# Honeycutt Hills Community

## STAIR LANDING FRAMING

M+K Project #: 126-23047 (40/05)

sheet:  
**S2.0**

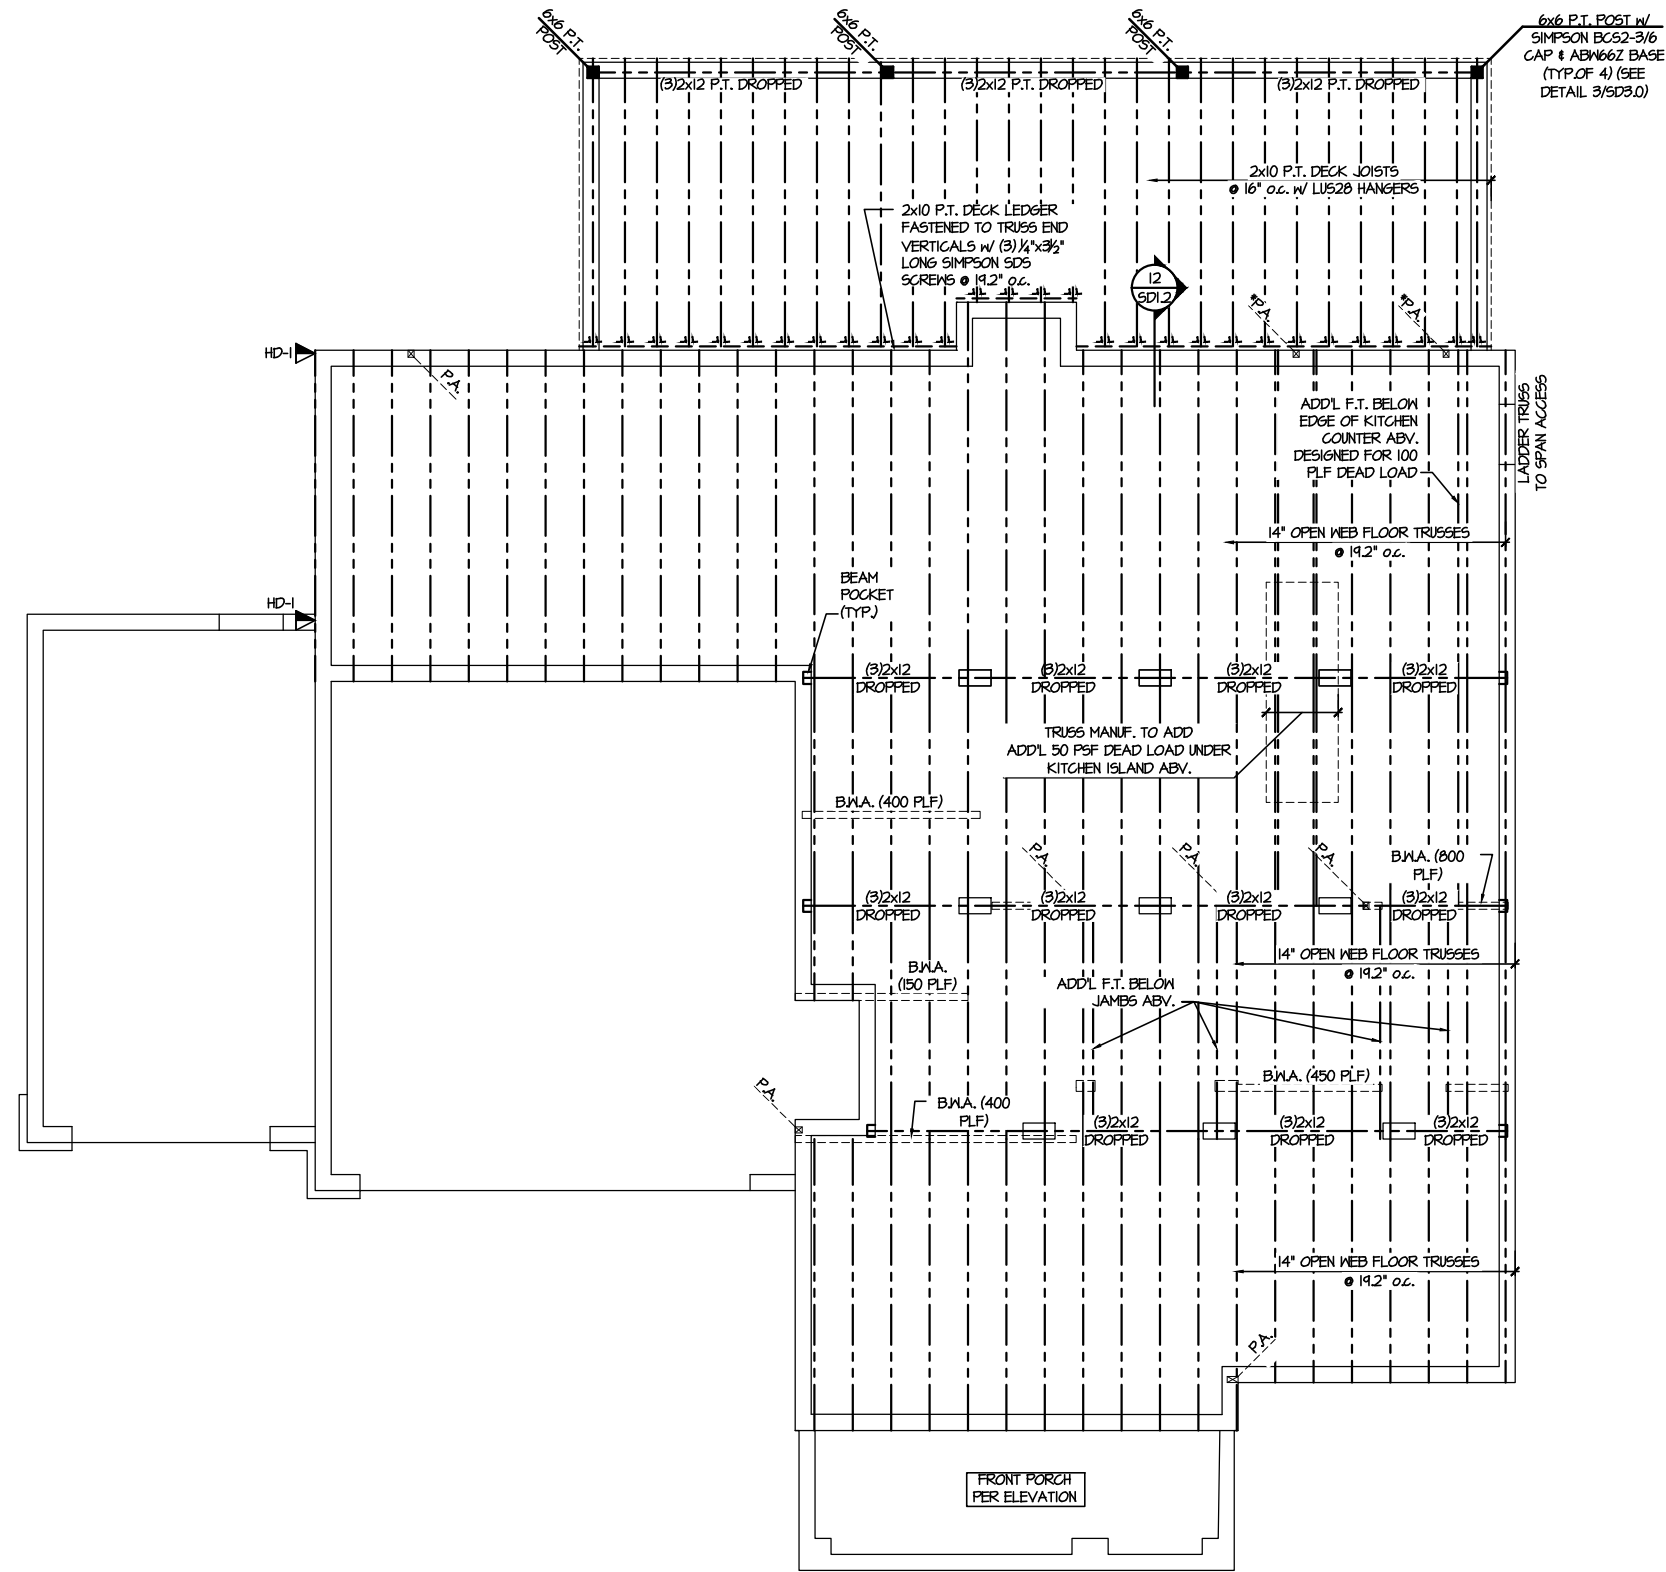
Pursuant to your request, we have prepared this letter to address an alternate framing method of constructing the stair landing that differs from the structural plans for lots in the above-referenced community.

It is our professional opinion that the stair landing is structurally adequate to be framed with 2x8 joists pocketed into the bearing wall with full bearing on a 2x4 bearing wall stud below directly adjacent to a full height 2x4 bearing wall stud. Each 2x8 landing joist should be fastened at each end to the adjacent full height 2x4 bearing wall stud with (2) 3" long x 0.120" diameter nails. This letter applies to lots within this community that have the above-described as-built framing condition. If a different as-built framing condition occurs other than this described case, please contact Mulhern & Kulp for additional analysis and documentation.
